**WEST SUSSEX COUNTY COUNCIL
STRATEGIC PLANNING CONSULTATION**

SUBJECT: A/64/17/DOC - Application for approval of matters reserved by conditions imposed under A/173/16/PL relating to Conditions 3 - Schedule of materials, 5 - Construction site set up, 7 - Covered parking & secure cycle spaces & 9 - Landscaping scheme.

Land R/O, 1 - 6 The Cottrells, Angmering

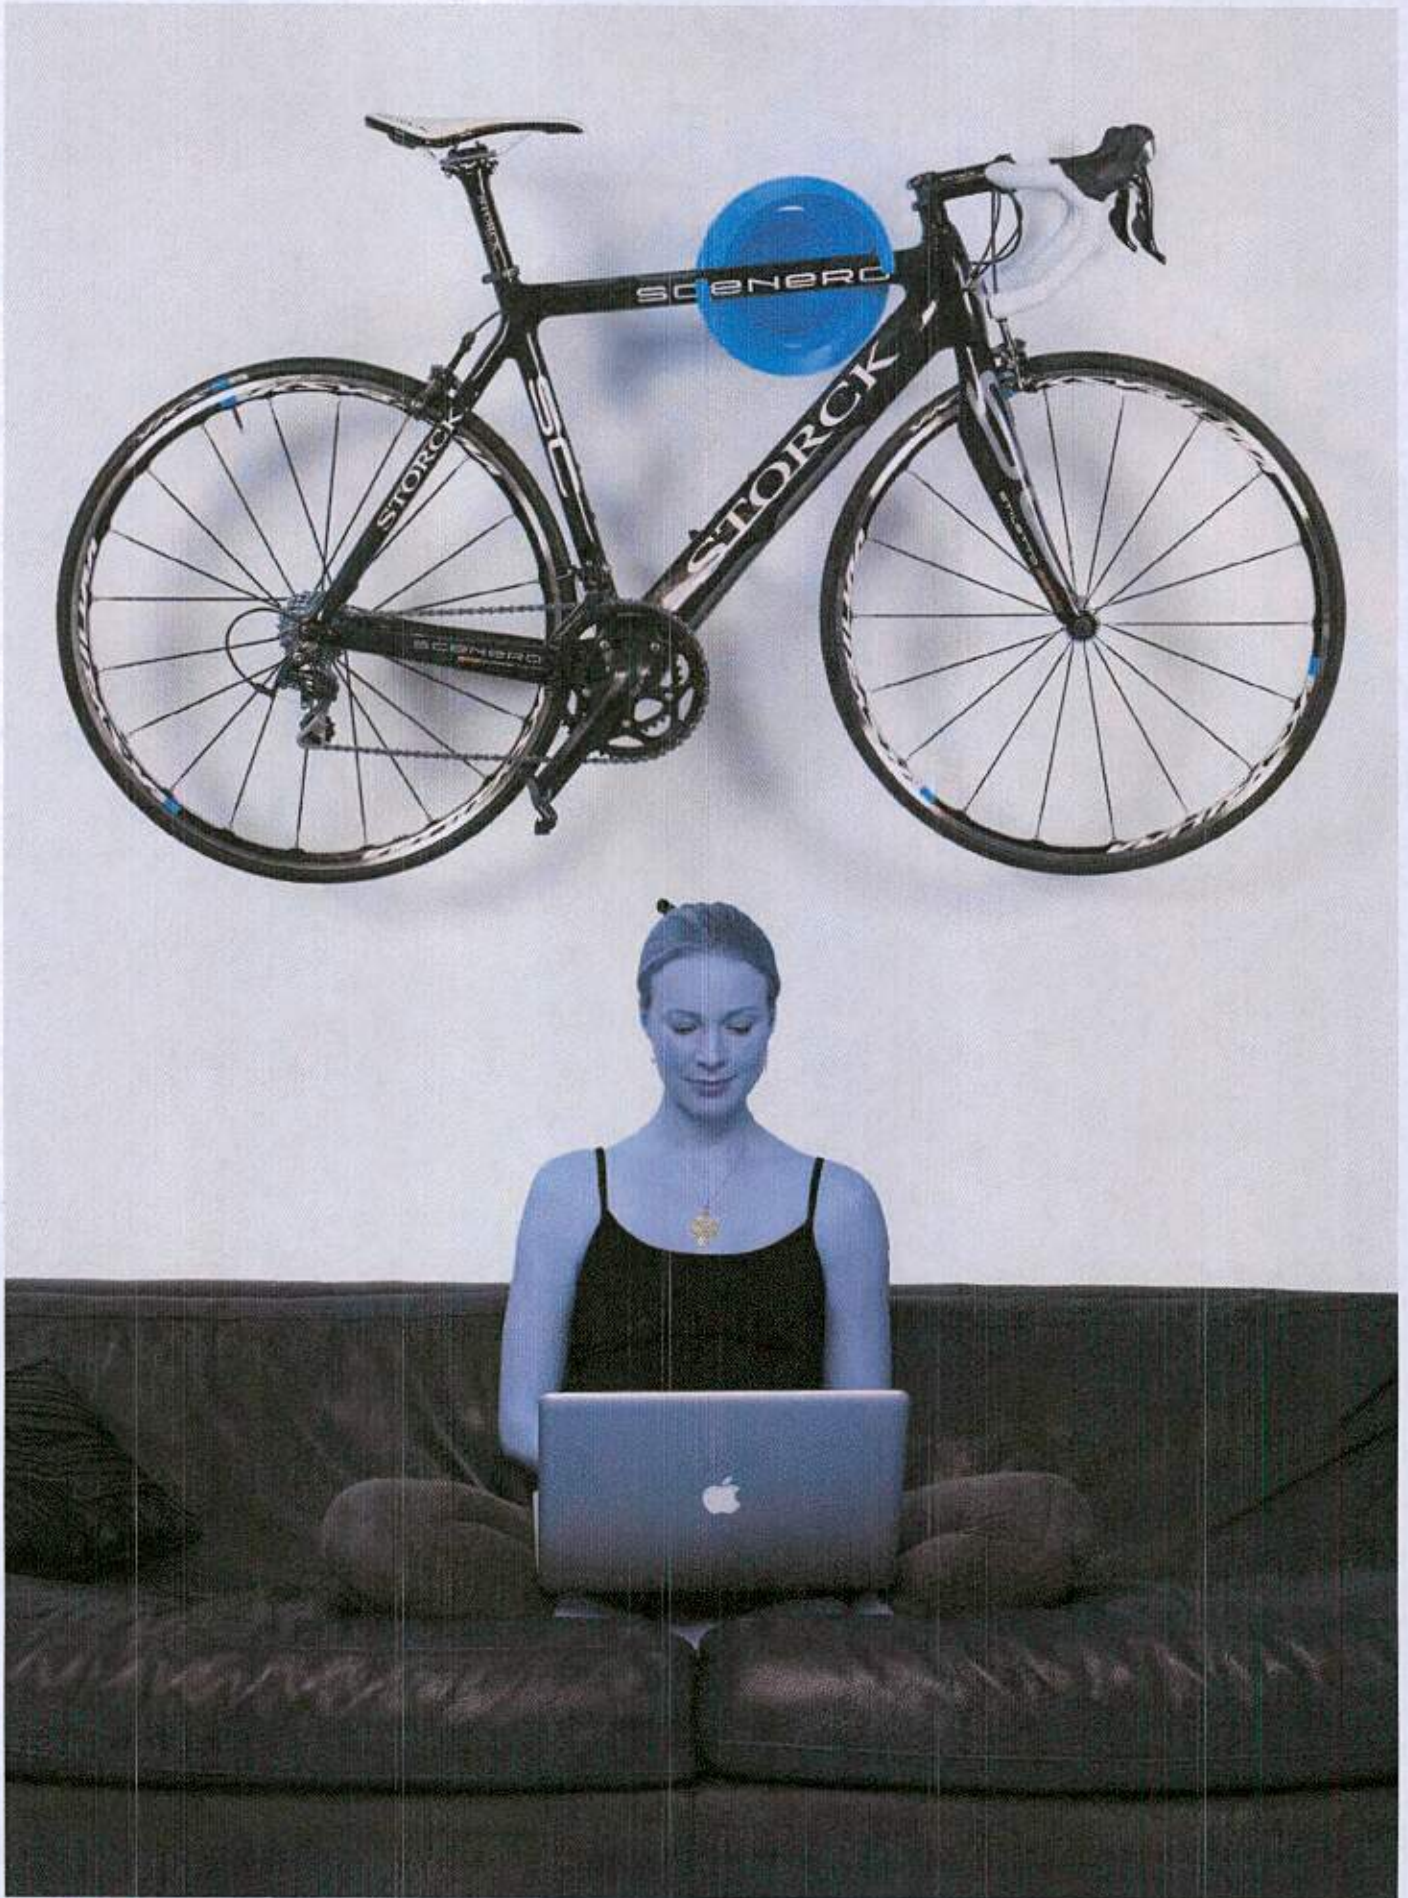
Condition 7 - Covered parking & secure cycle spaces
The applicant has provided details of 'Cyloc' storage bracket, of which two will be located within the car port adjacent to parking space 5. These details would be considered acceptable.

Rev	Description	Date
Job Reference New House The Cottrells Angmering Client AM Homes Ltd		
Drawing Title Site Works Plan Drawing No AD962/03 Rev		
Date	Scale	Dwg Size
28.02.17	1:100	A3
	Plot Style	Drawn
	ADCgreycols	TDG
	Checked	AD

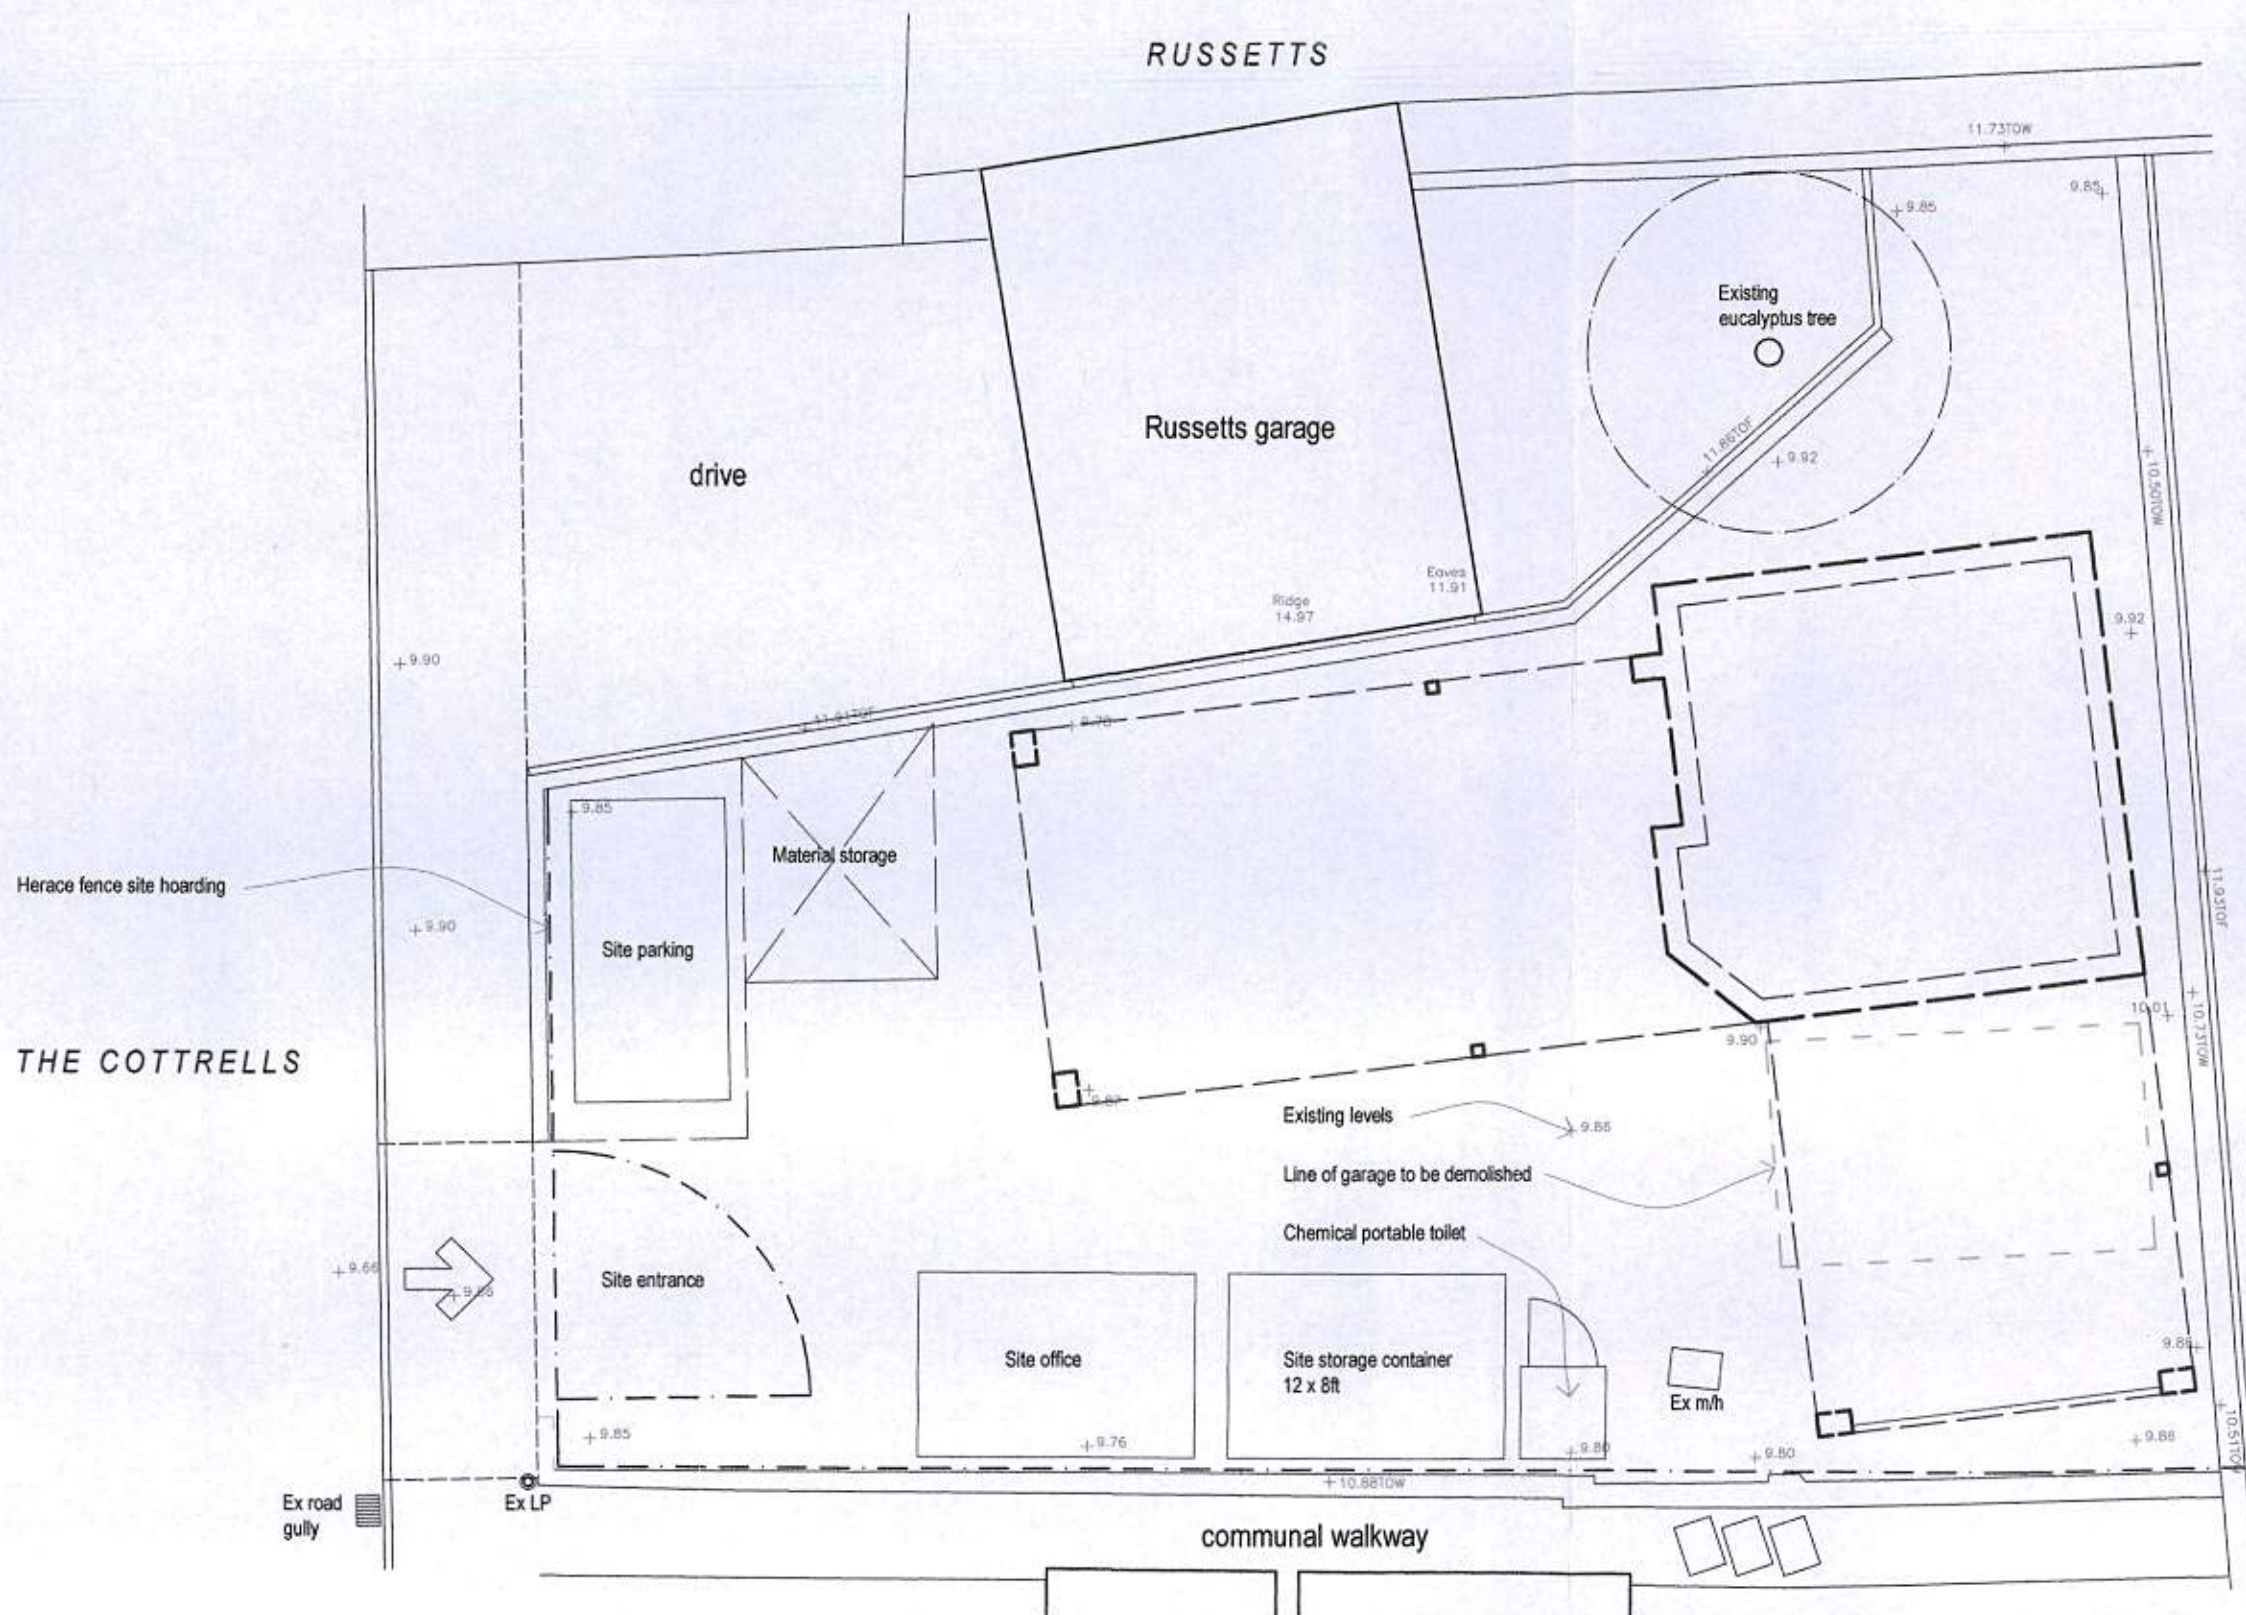
Condition 5 - Construction site set up
The applicant has provided a plan AD962/03 detailing the site set up during construction. All storage of plant and materials will be contained within the site. With one parking space provided for contractor parking. These details would be considered acceptable.

The condition also states that details pertaining to the unloading and loading of vehicles is to be provided. From inspection of the details provided this has not been supplied. Will loading and unloading take place within the site or on street from The Cottrells? The applicant should clarify these details.
